Memorandum ABP-314501 – Request for Further Information

Re: South Dublin Street and Backlands Regeneration Project. The proposed

Date: 10th February 2023

**MGT0528-
RPS-00-XX-
DR-C-DR1001
- Drainage
(Planning Issue)**

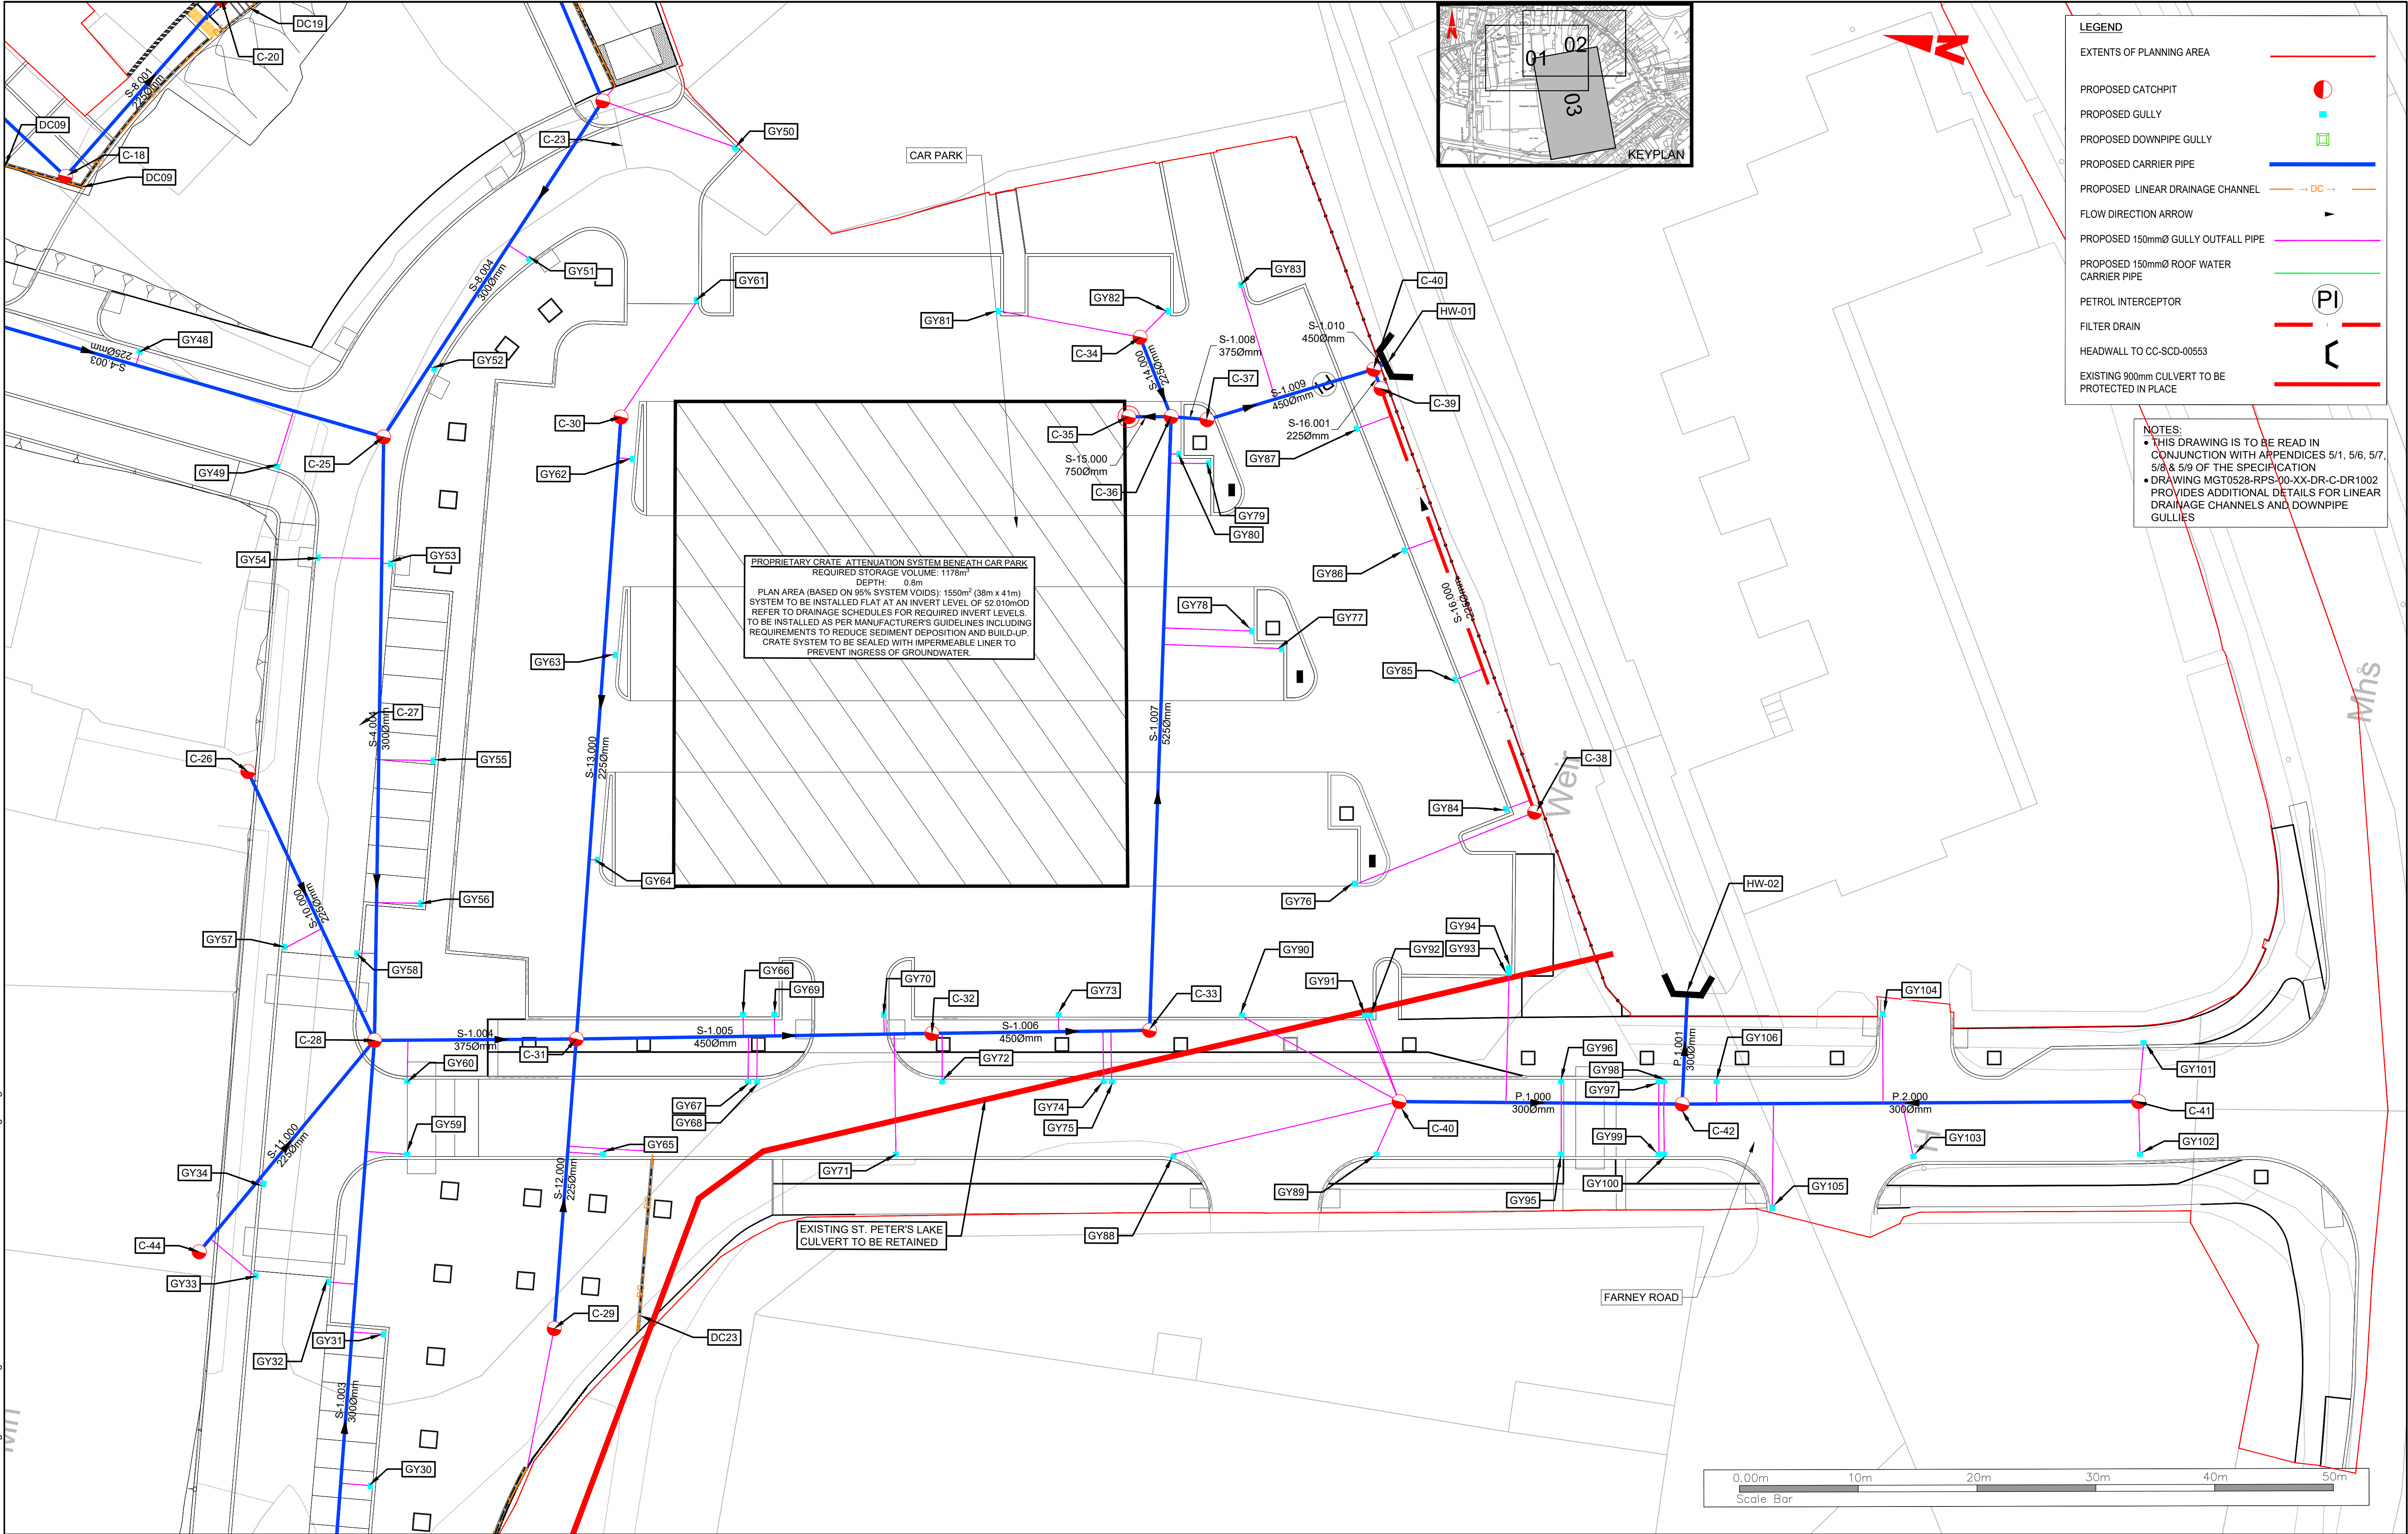
- a) Table 6.8 is a repeat of Table 6.9: summary of Ortho-Phosphate. Please submit the correct Table 6.8 Summary of Total Oxidised Nitrogen, and include a statement as to whether or not the levels are indicative of high or good quality or otherwise.
- b) The Drainage Layout Map, drawing no. DR1001 does not indicate the proposed water or sewerage network. Please submit a site layout plan detailing these proposed networks.
- c) Submit a site layout plan indicating existing service networks in the site, to include water and sewerage.
